**RFI**

RFI #: 80  
Date: 3/20/2012  
Job: EB-02 Keller Springs Lofts  
Phone: 877-777-5115

Subject: Elevation conflict with floors

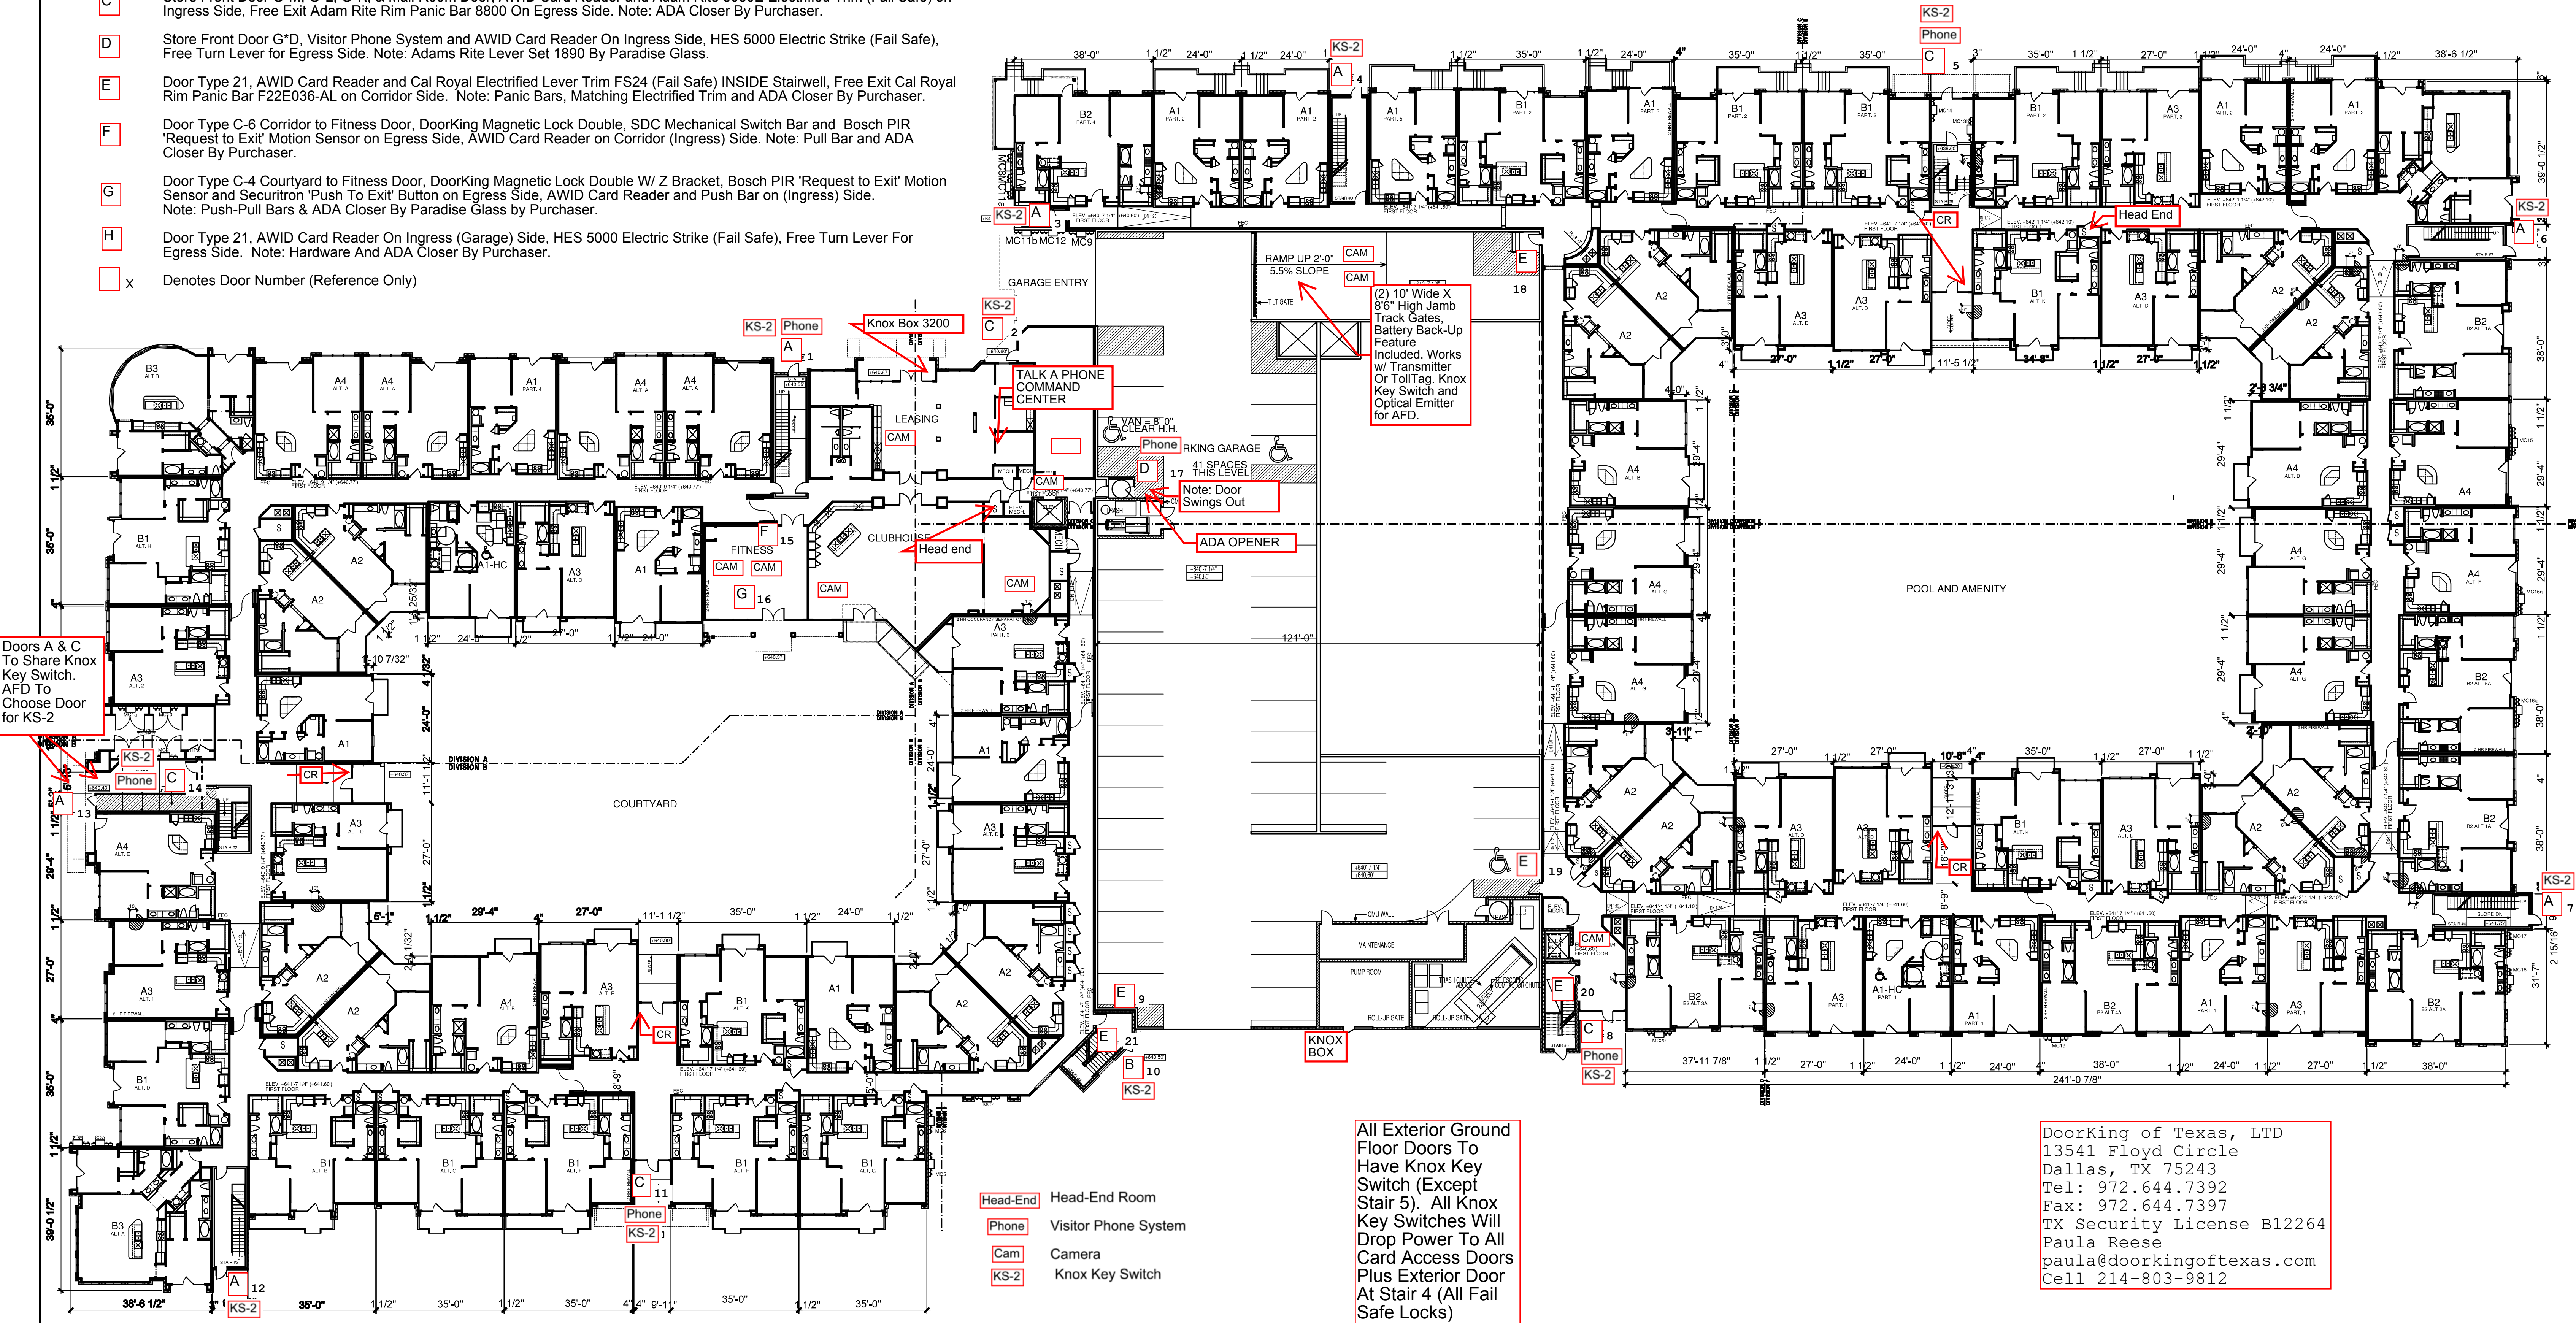
**Request:** Erik our framing subcontractor has an RFI. We think that there may be some discrepancies in the floor elevations that are shown on pages A3.1, A3.2, A3.3 and A3.4. We are basing this on the dimension 9'-1-1/8" (ceiling heights) that is shown for a section of 1st floor (page 3, 1e & 3, 1f) and is also given as the typical ceiling height for all 2nd 3rd and 4th floors. The 9'-1-1/8" ceiling height is a common / standard height for 9" walls and are constructed with (3) 1-1/2" plates and a 104-5/8" stud. With this being said our finish floor heights will be:

SHEET NUMBER
3.3

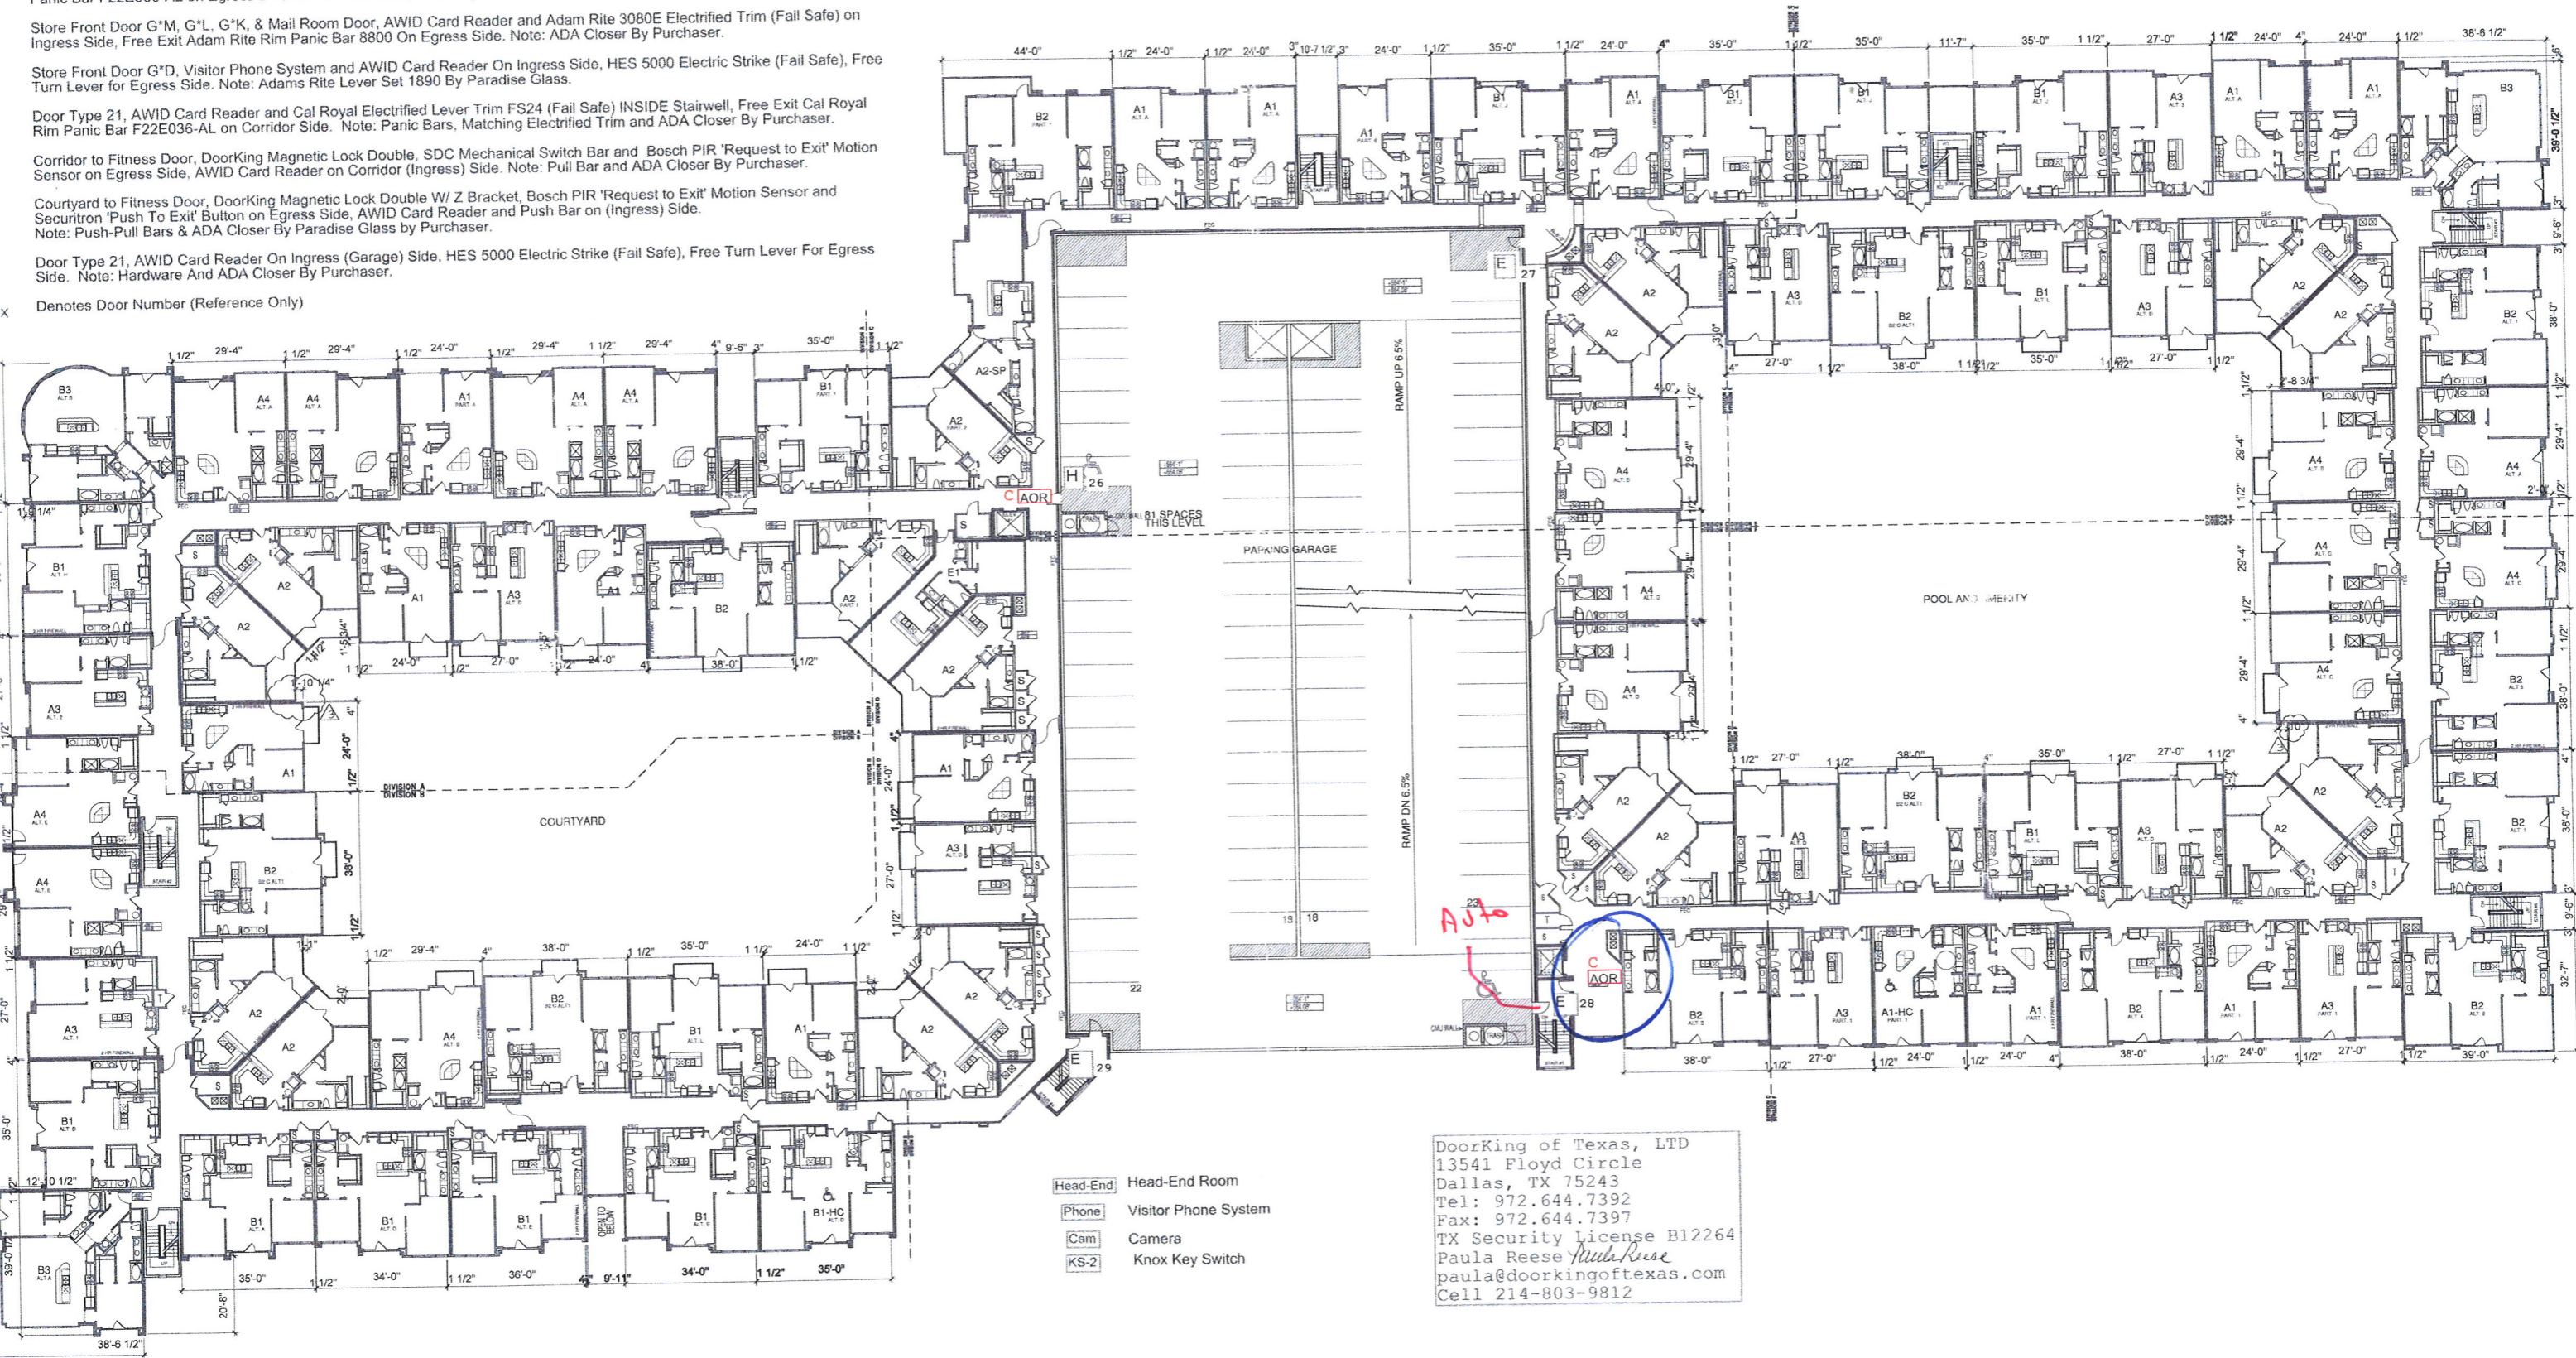
Thank you for addressing RFI #48. Your answer to #48 has us installing an additional 1x to the bottom plate to achieve specified elevations at 2nd 3rd and 4th floors around the parking garage. We do agree with adding the 1x to 2nd and 3rd floor bottom plates, but we think it should be to the entire 2nd and 3rd floors. The problem that we resolved around the garage is still present at the other stairwells. Here is a list of potential problems with installing the 1x to only parts of the floor

- 1 we will have step downs in the corridor ceilings
- 2 we will still have elevation problems at stairwell #s 1-2-3-5-7-8
- 3 floor plate differences at exterior elevations
- 4 the ramping of the floors (that you have addressed)
- 5 we will have to add a 1x to top of 4th to all areas not raised or field cut all of the studs in your shaded area to achieve proper roof truss bearing.

In summary we think that we should install the 1x to all of 2nd and 3rd floor bottom plates. Erik this was previously discussed with the Project Manager David Gallagher, the Project Super Brian Peterson and with you and agreed upon by all parties.

- 2nd floor 65'4"-1/16 (good)
- 3rd floor 65' 11-15/16 (1-1/16 inch low)
- 4th floor 67' 7-13/16 (2-1/16 inch low)

Typically on a wood framed building you can expect about a 1/2" of growth in height per floor. However this still will be short of your target elevations. Has the steel & stairs been put into production? Can the elevation be adjusted? If not we may need to look at the option of adding a 1x to 2nd and 3rd floor sills. I have attached a drawing for your review. This drawing shows the actual finish floor elevations using 3 plates and a 104-5/8" stud. Please advise.

**Response:** BGO agrees and has no exception to this change.

**Response:** Please add a 1x4 mudsill at 3rd and 4th floors as shown on sheets 3.3.1 and 3.4.1 (next pages of this PDF).
